An  
Bord  
Pleanála

## Inspector's Report

### ABP-314204-22

Material change of use of existing dwelling to residence where care is provided for persons with intellectual or physical disability and ancillary site works all which is within SAC and pNHA.

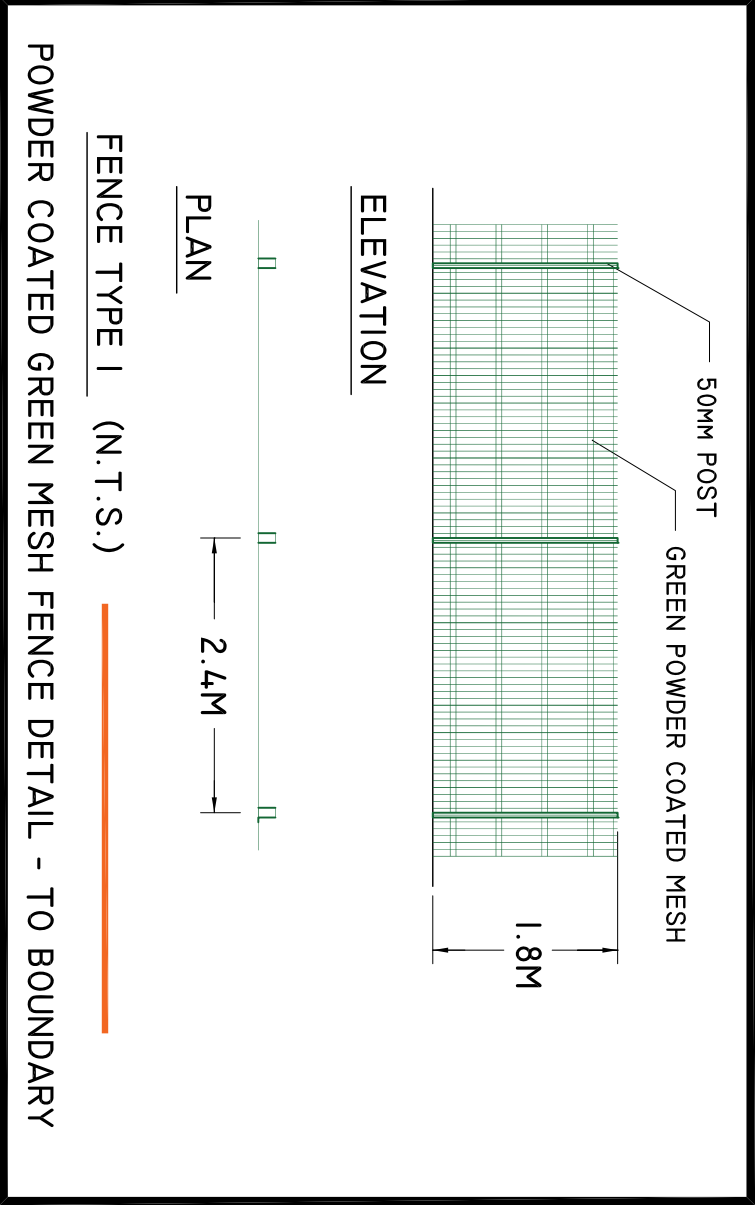
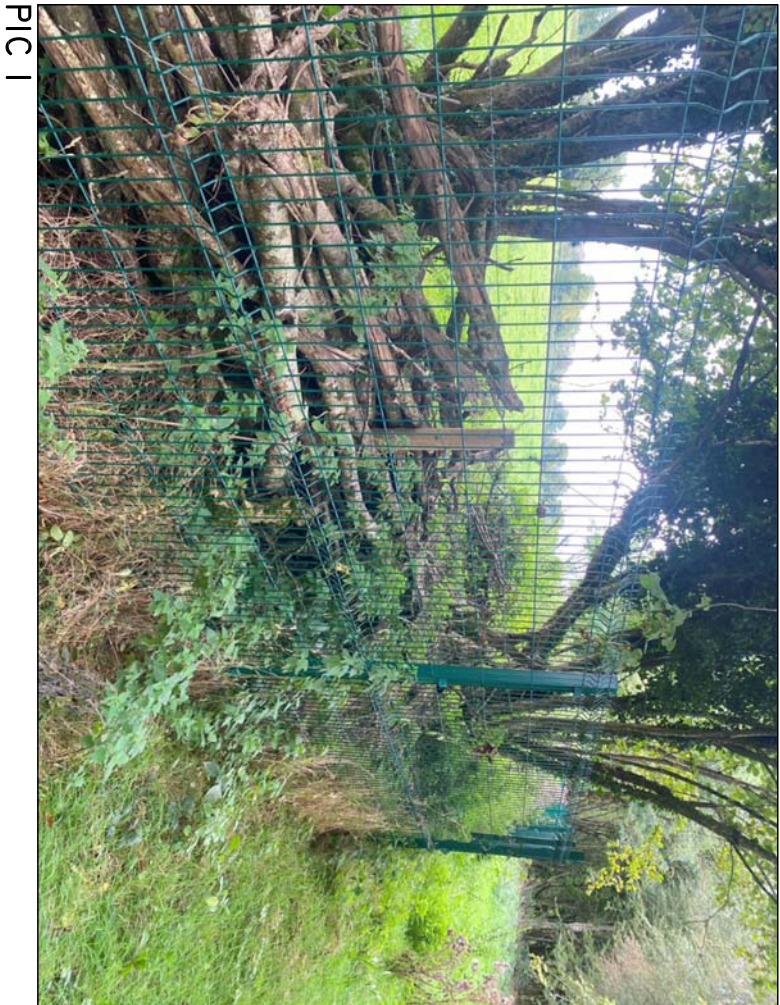
Works have already commenced with the applicant constructing a fence along the boundary of the land right into the lake, widening of the gateway and deposit of large volumes of stone and the movement of stones along the shoreline. It is noted that the applicant has not proposed to retain any of these works.

- 7.5.1. Access along the shore line is referred to in the documentation with reference to the issue of the erection of a fence. The erection of a fence is not addressed in the application.

- 7.6.2. It also appears that the entire development has not been documented. The planner's report refers to development carried out by the applicant which is not addressed in the application. It refers to the applicant constructing a fence along the boundary of the land right into the lake, widening of the gateway and deposit of large volumes of stone and the movement of stones along the shoreline.
- 7.6.3. The visual impact and extent of the proposed development are reasons for refusal.
